City of Portland, Maine - Building or Use Permit Application

Permit No: 04-0172		Issue Date:	CBL: 015 E012001
Location of Construction: 105 North St	Owner Name: Ckt Inc	Owner Address: Po Box 427 1	Phone: 207-774-5358
Business Name: n/a	Contractor Name: n/a	Contractor Address:	Phone:
Lessee/Buyer's Name n/a	Phone: n/a	Zone: R6	
Past Use: Multi Family / 3 Units	Proposed Use: 3 Units / Replace 10' x 43' x 48' x 10' roof top deck.	Permit Fee: \$246.00	Cost of Work: \$25,000.00
Proposed Project Description: Replace 10' x 43' x 48' x 10' roof top deck. <i>legal use: 3 dwelling units -</i>		FIRE DEPT: <input checked="" type="checkbox"/> Approved <input type="checkbox"/> Denied	INSPECTION: Use Group <i>2</i> Type <i>SB</i> <i>REPLACEMENT DECK</i> <i>3/2/04</i>
		Signature <i>[Signature]</i>	Signature <i>[Signature]</i>
		PEDESTRIAN ACTIVITIES DISTRICT (P.A.D.)	
		Action: <input type="checkbox"/> Approved <input type="checkbox"/> Approved w/Conditions <input type="checkbox"/> Denied

Proposed Project Description: Replace 10' x 43' x 48' x 10 roof top deck.
--	---

RE: 105 North Street Deck

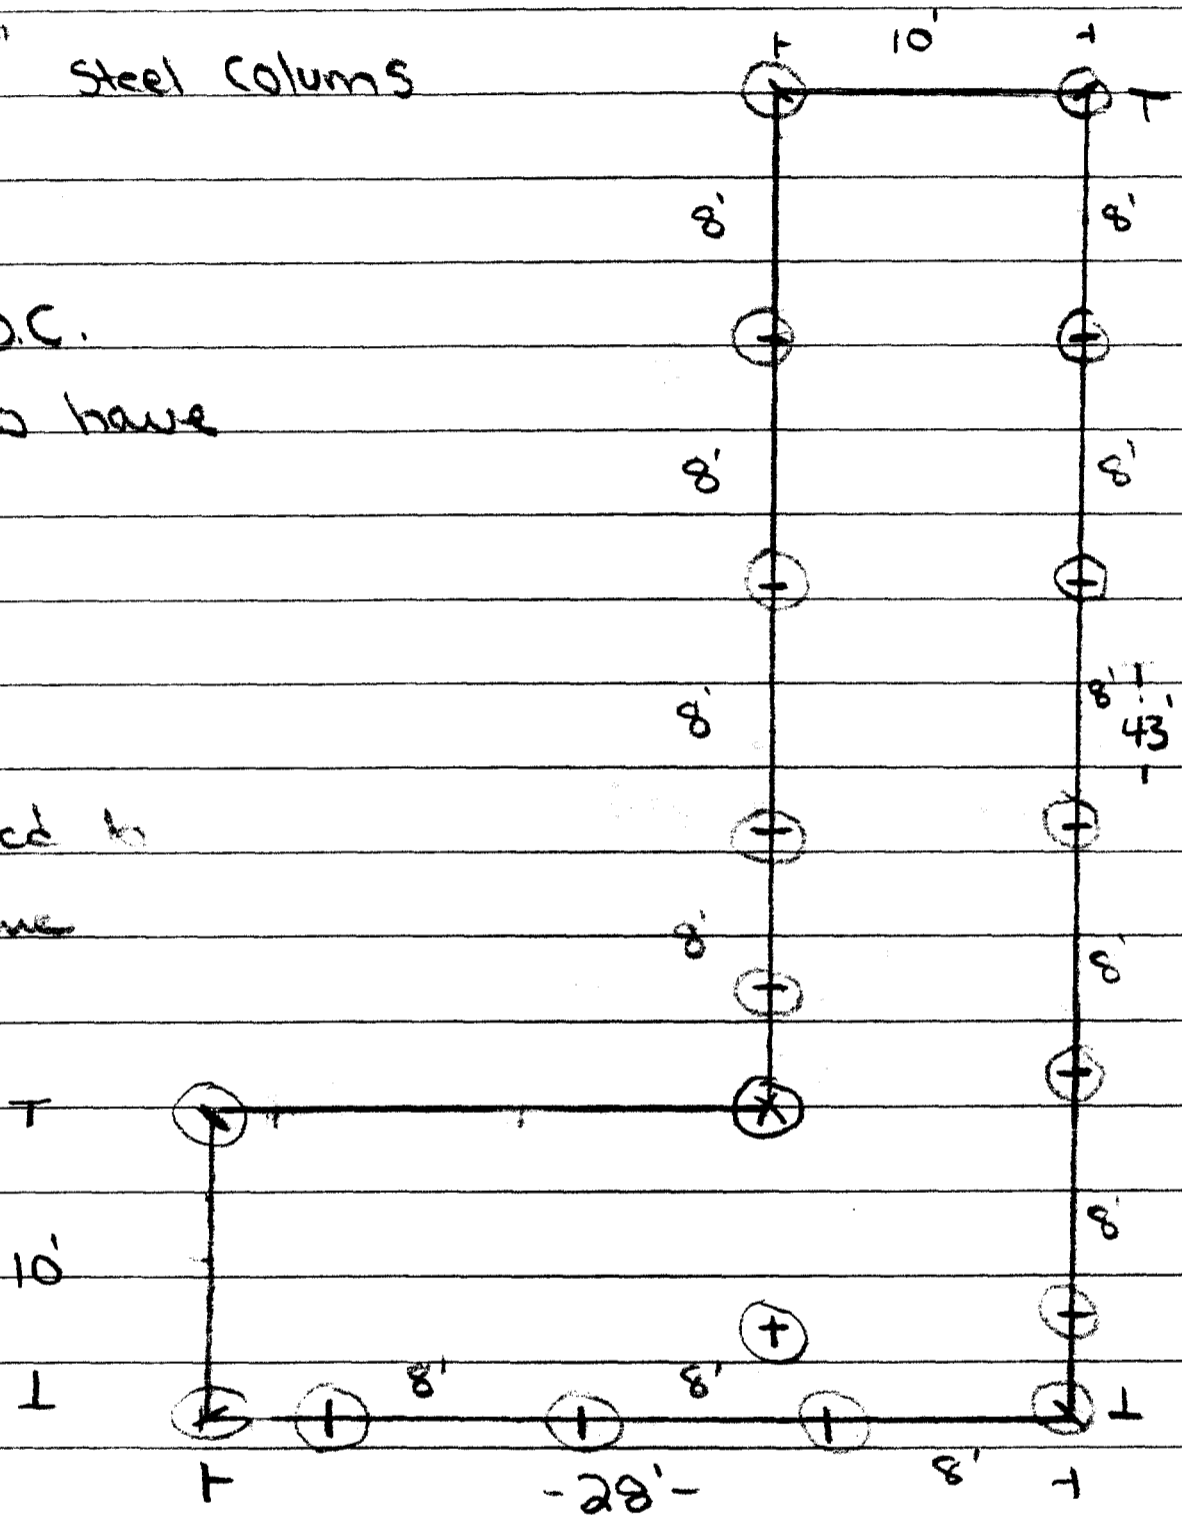
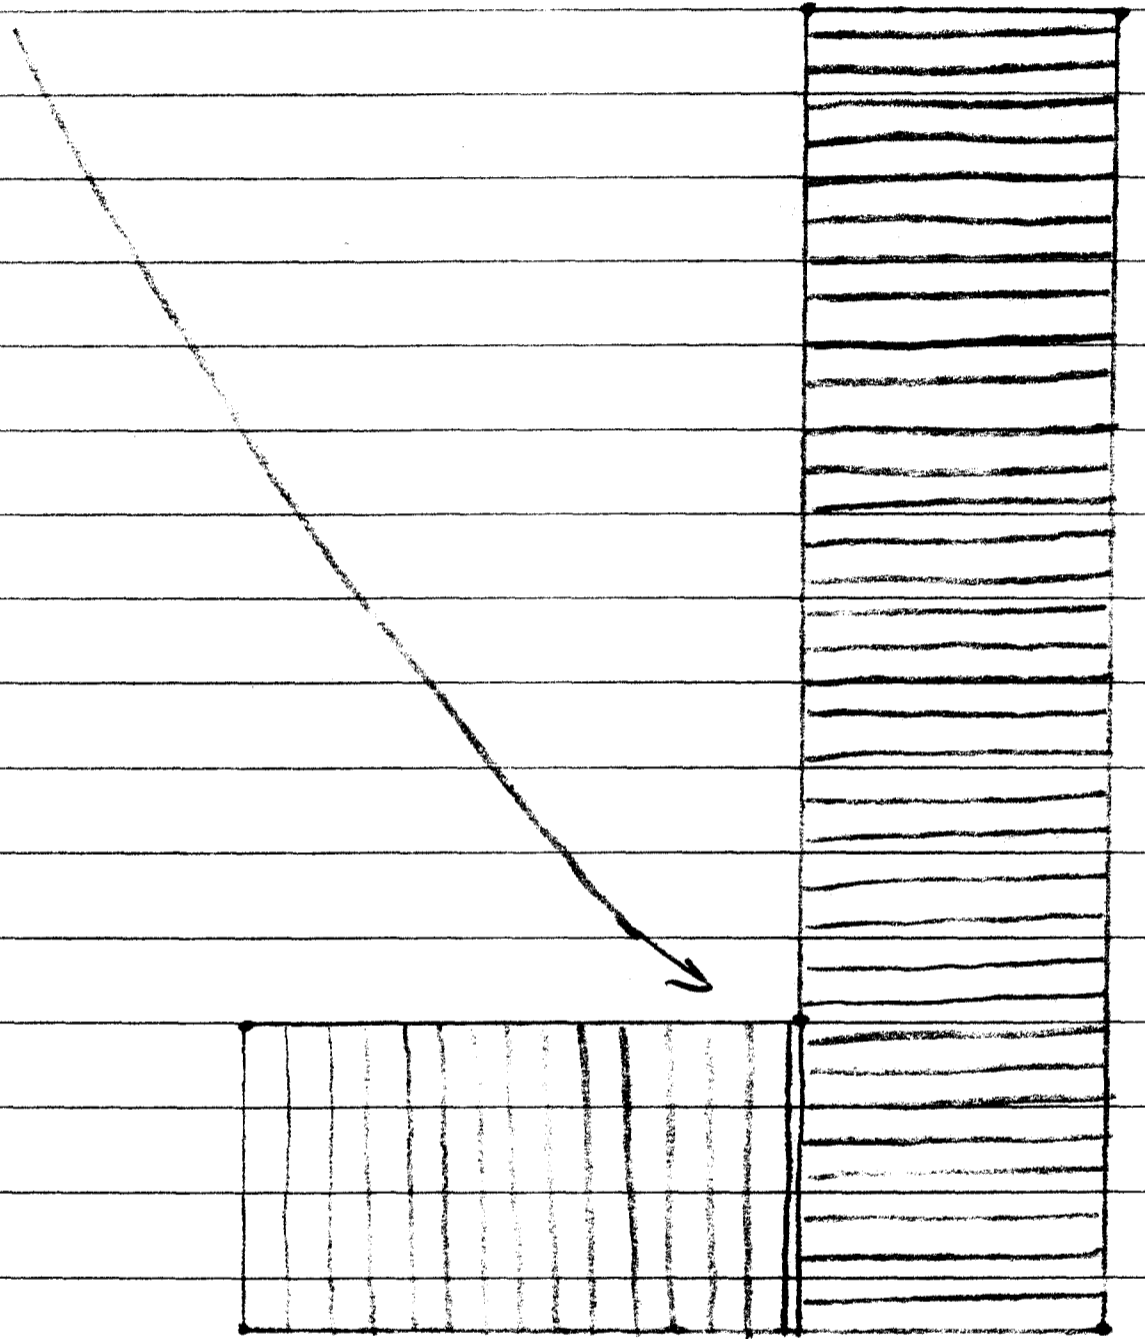
Dept: Building	Status: Approved with Conditions	Reviewer: Mike Nugent	Approval Date: 07/21/2004
Note:			Ok to Issue: <input checked="" type="checkbox"/>
1) The ceiling of the unit below must be made accesible to confirm that the structural repairs indicated by the design professional occurred. VERY IMPORTANT!!!

After looking **at** the deck on Wednesday, I find that the deck, as built, exceeds the capacity of the roof joists below. Attached is sketch for transferring the deck load into the **wall below**. When this work is done, the structure **is** adequate **for** supporting **the** deck load.
